Development Facilitation Team (DFT) – Review Comments

Project No: PR-2024-010189 Date: 4/23/2025 Agenda Item: #4 Zone Atlas Page: (H-8, J-7, J-8)

Request: Subdivide Tract N-1 into two tracts

Location: 9601 Tierra Pintada Blvd between Tierra Pintada Blvd NW and Arroyo Vista Blvd NW

SIDEWALK EXHIBIT

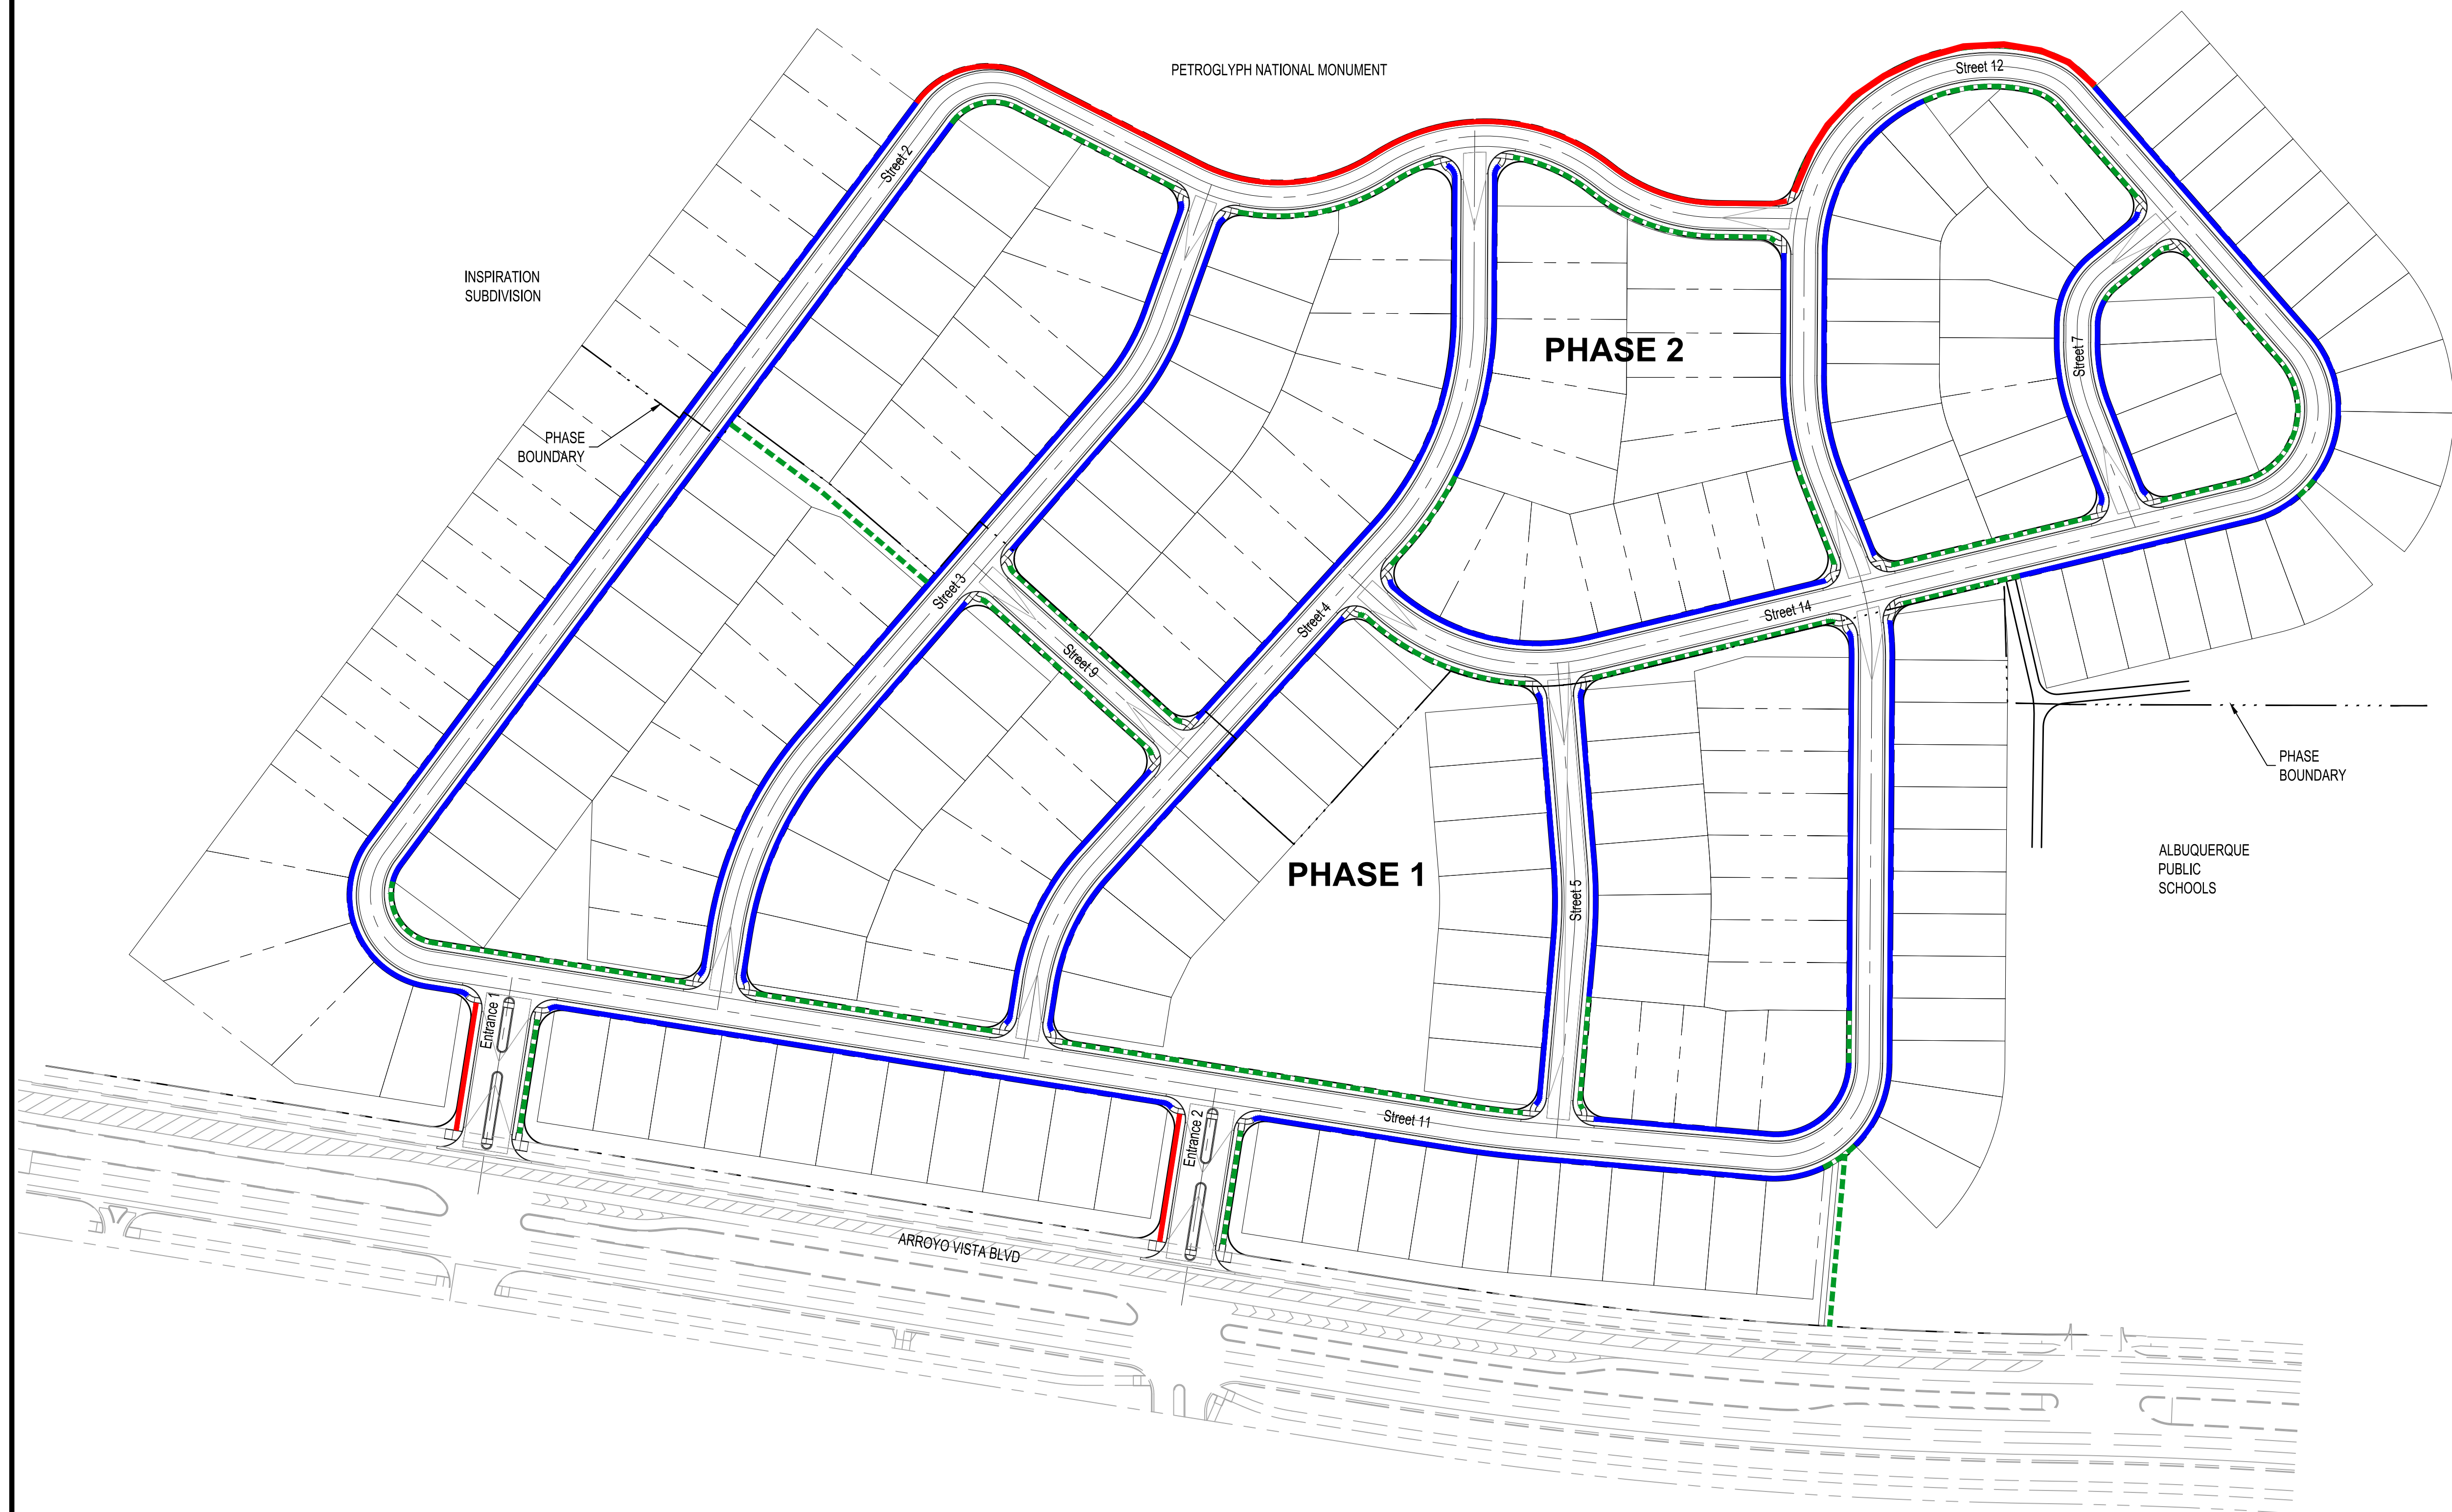
1. No objection to the vacations. No objection to the determination for ROW width.
2. Your request for Waiver of centerline radius and block length do not show what the proposed radii and block lengths waived would be. Please provide this information.
3. Your sidewalk waivers do not follow procedures of IDO request for waiver as there is no justification of the 10 criteria listed.
4. Transportation does not support the deferral of sidewalk to the construction of individual homes as this will create unnessesary gaps as subdivision develops. Sidewalks should be constructed with the curb, gutter and streets.
